Application No: CM/53/20/PL
Site Address: Land at Wren Cottage Horsemere Green Lane Climping BN17 5QZ
Description of works: Development of 2 No 2-bed & 2 No 3-bed detached dwellings & associated works.
This site is in CIL Zone 3 and is CIL Liable as new dwellings.

Thank you for your internet representation made on 28th January 2021 which has been recorded as an objection with the comments as follows:

Council objects to the application for the following reasons:

SITE PLAN
SCALE 1:500 @ a3

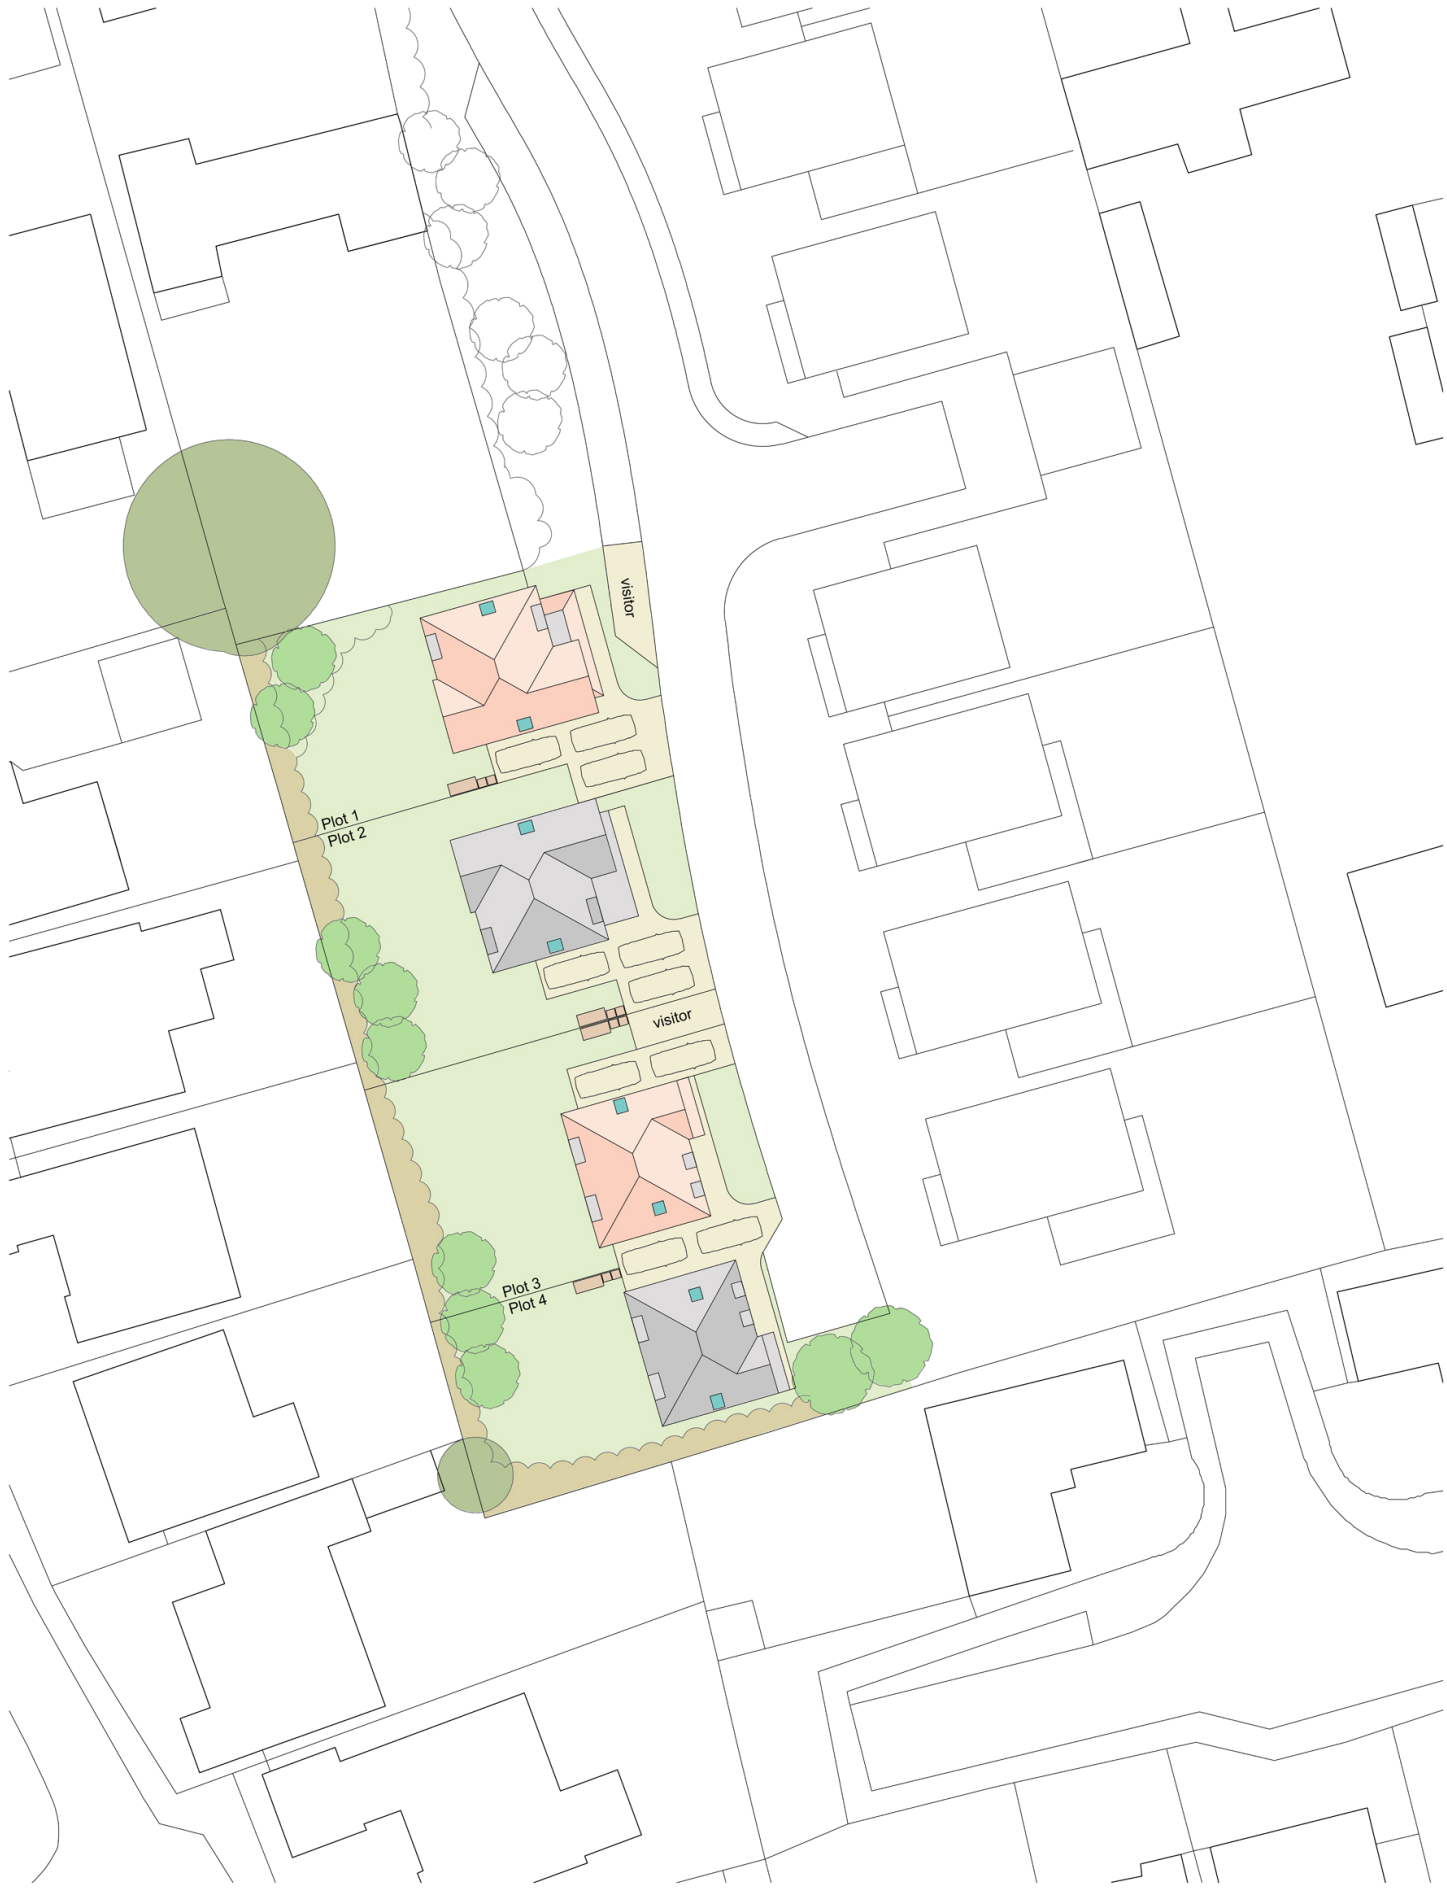
1. The dwellings are too close to the properties in Wooldridge Walk and Council is concerned that this will be overbearing on those properties and unduly overlook them affecting privacy

2. Two storey dwellings are out of character to the bungalows in Wooldridge Walk contrary to the Clymping Neighbourhood Plan Policy CPN 11
3. There is no provision for an amenity space. The development uses the same access as the 9 dwellings approved in application CM/21/19/PL (Land adjacent to Sclyd) so the access will serve 13 dwellings if this application is approved. If there had been one application for 13 dwellings there would have been a requirement to provide an amenity space/children's play area. Provision of an amenity space should be required in this application in the interest of neighbourhood amenity as the overall development is being extended.

4. Regarding the road layout and parking facilities:
 - There is insufficient visitor parking
 - There is no turning point at the end of the road access to these 4 dwellings and this will create problems for cars and delivery/rubbish collection vehicles etc. The turning point halfway in does not address this problem

- Access is through Sclyd and onto Horsemere Green Lane. The access junction on to Horsemere Green Lane needs to be re-assessed to allow for 13 dwellings to safely use it.

ECOLOGY ENHANCEMENT PLAN
SCALE 1:500 @ a3

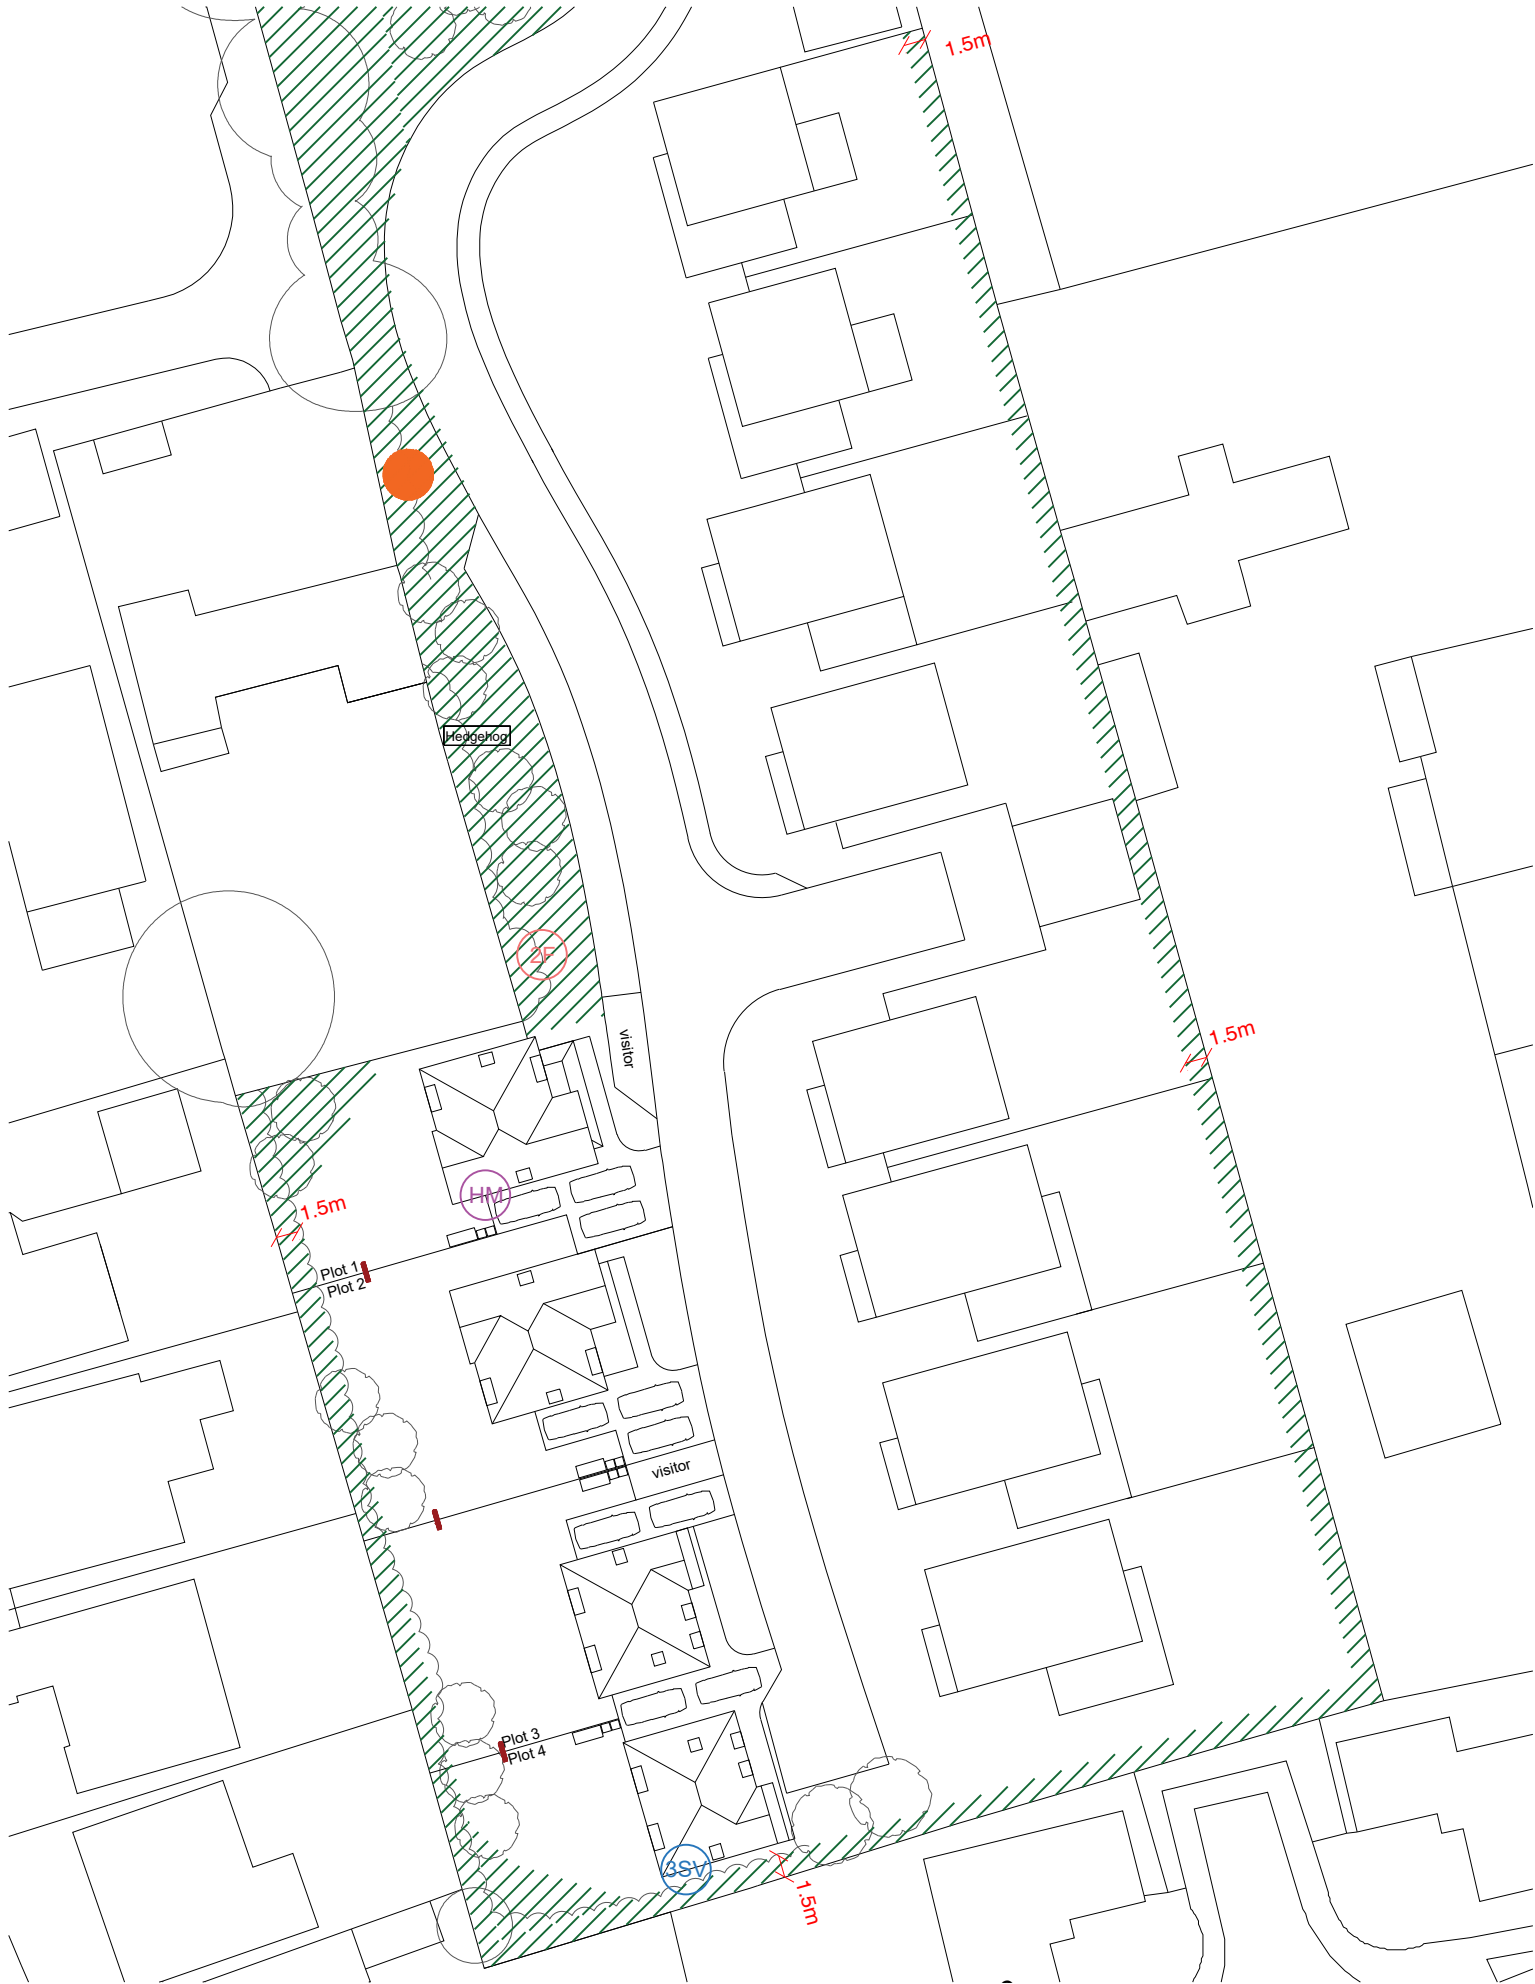
5. Council is concerned about the further loss of habitat for both flora and fauna. A full survey and assessment of the effect on displaced wildlife life and loss of vegetation and trees should be carried out.
6. Given the recent findings of a geophysical survey for a nearby site resulting in archaeological works a geophysical survey should be required for this site
